Director, Transport Assessments
Department of Planning and Environment
320 Pitt Street
SYDNEY NSW 2000

WESTCONNEX M4-M5 LINK (SSI 16_7485) - SUBMISSIONS AND PREFERRED INFRASTRUCTURE REPORT (SPIR)/DRAFT CONDITIONS OF APPROVAL

21 February 2018

Figure 2-1 Indicative White Bay civil site (C11) layout

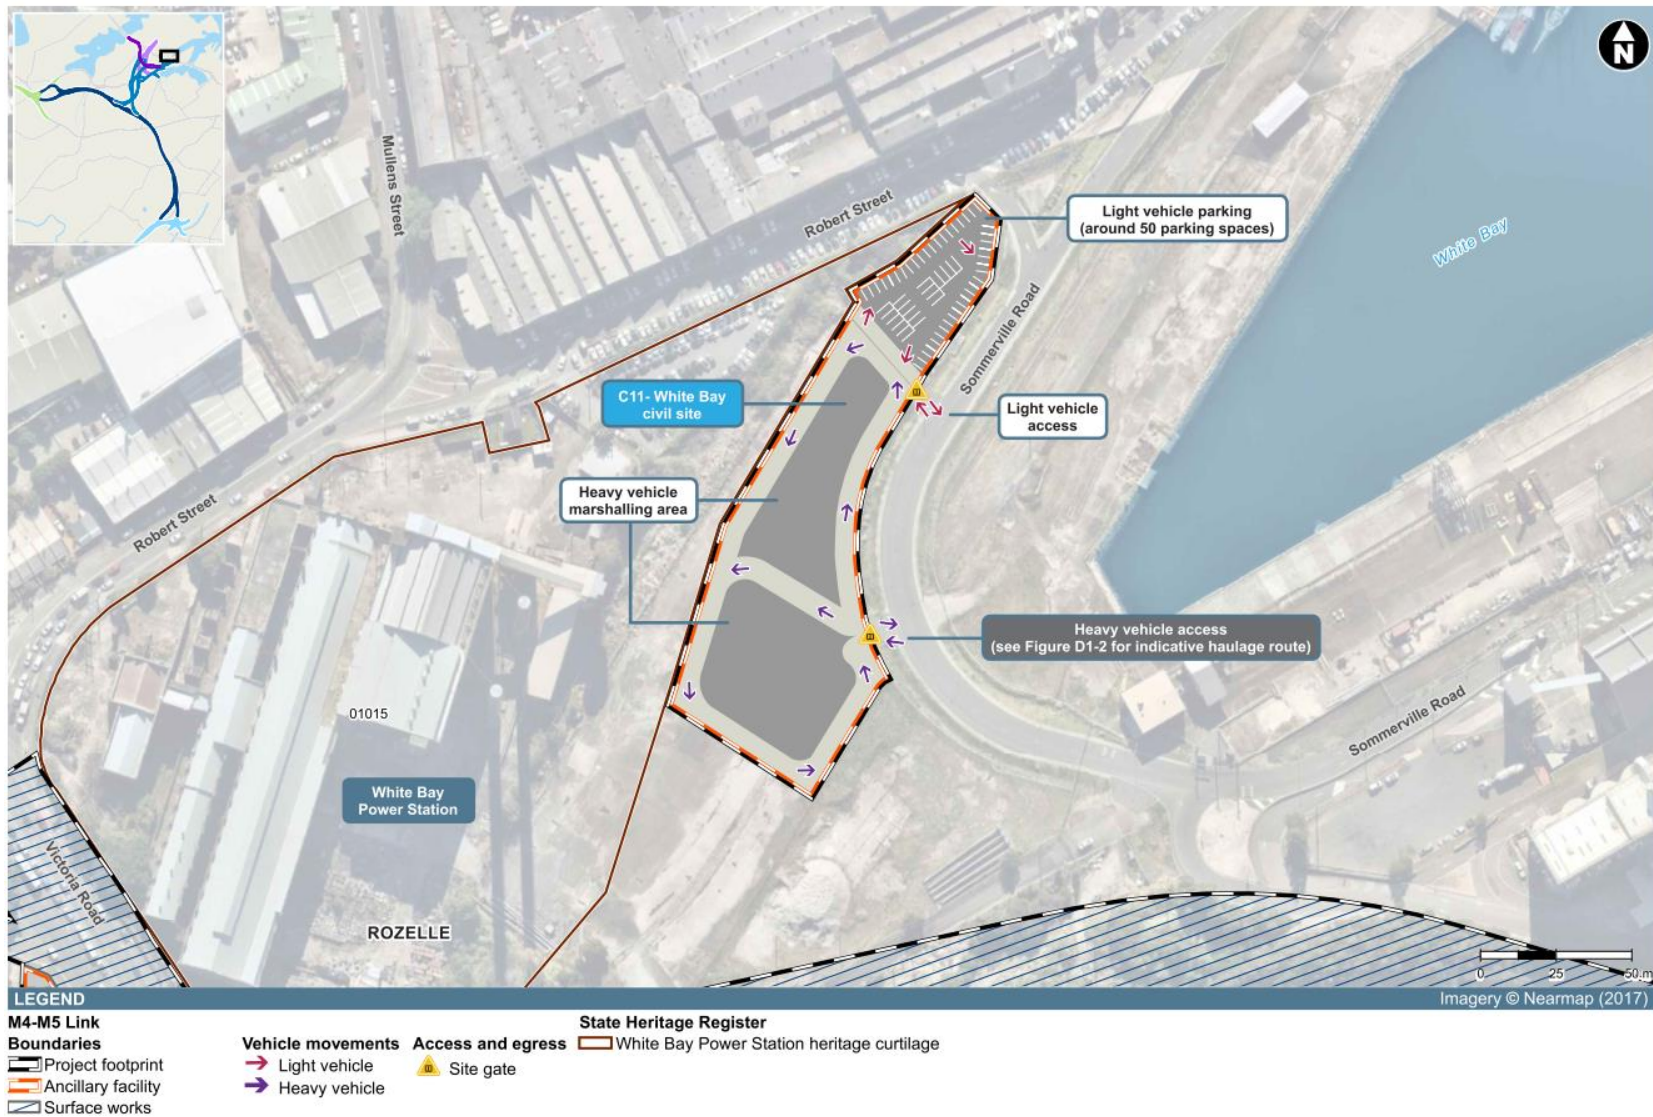
The Port Authority also notes that a new additional construction ancillary facility (the White Bay civil site (C11)) is now proposed in the Preferred Infrastructure Report (which was not reported in the EIS).

The Port Authority refers to the cumulative traffic impact assessment for Cluster 3 (which covers the section of City West Link adjacent to Rozelle civil and tunnel site (C5) and White Bay civil site (C11) including The Crescent/James Craig Road intersection) presented in the Technical Working Paper: Traffic and Transport (the Traffic Report). The cumulative traffic impact assessment in the Traffic Report excludes from the assessment potential infrastructure construction logistics projects at Glebe Island on the basis that they are at early stages in the planning process and due to associated uncertainty about approvals, timing, etc. In this regard, it is noted that the Western Harbour Tunnel and Warringah Freeway Upgrade Scoping Report (October 2017) prepared by Arcadis/Jacobs for RMS indicates that Glebe Island will be used as a spoil handling area for the Western Harbour Tunnel and Warringah Freeway Upgrade project, up to approximately 2022. Should this proposal be approved, traffic from this project would need to access/egress Glebe Island via Sommerville Road and James Craig Road and its intersection with The Crescent. In addition, the Port Authority has been approached by the Sydney Metro project team with a proposal to use part of White Bay as a truck marshalling yard for the Metro project. Again, should this proposal proceed, traffic from this project would need to access/egress Glebe Island via Sommerville Road and James Craig Road and its intersection with The Crescent. The Traffic Report has also not included a specific allowance for traffic generated by the White Bay cruise ship terminal on the basis that the draft licence between Port Authority and RMS does not allow access to the site from Sommerville Road and James Craig Road during defined time periods (peak traffic periods) on days when the cruise ship terminal is operating. However, cruise related traffic occurs throughout the period of a cruise ship being at berth, not just at the identified peak times.

Based on the above exclusions, the cumulative traffic impact assessment presented in the Traffic Report does not reflect the likely traffic environment on the Port Authority's roads and James Craig Road and its intersection with The Crescent during the period of the proposed C11 and C5 sites. The Port Authority considers that the Traffic Report will therefore need to be updated if the above projects are approved and also once the licence/agreement between Port Authority and RMS for the use of the ancillary construction facility "White Bay civil site (C11)" has been finalised, in order to ensure effective traffic coordination and the minimisation of traffic impacts on port users and activities.
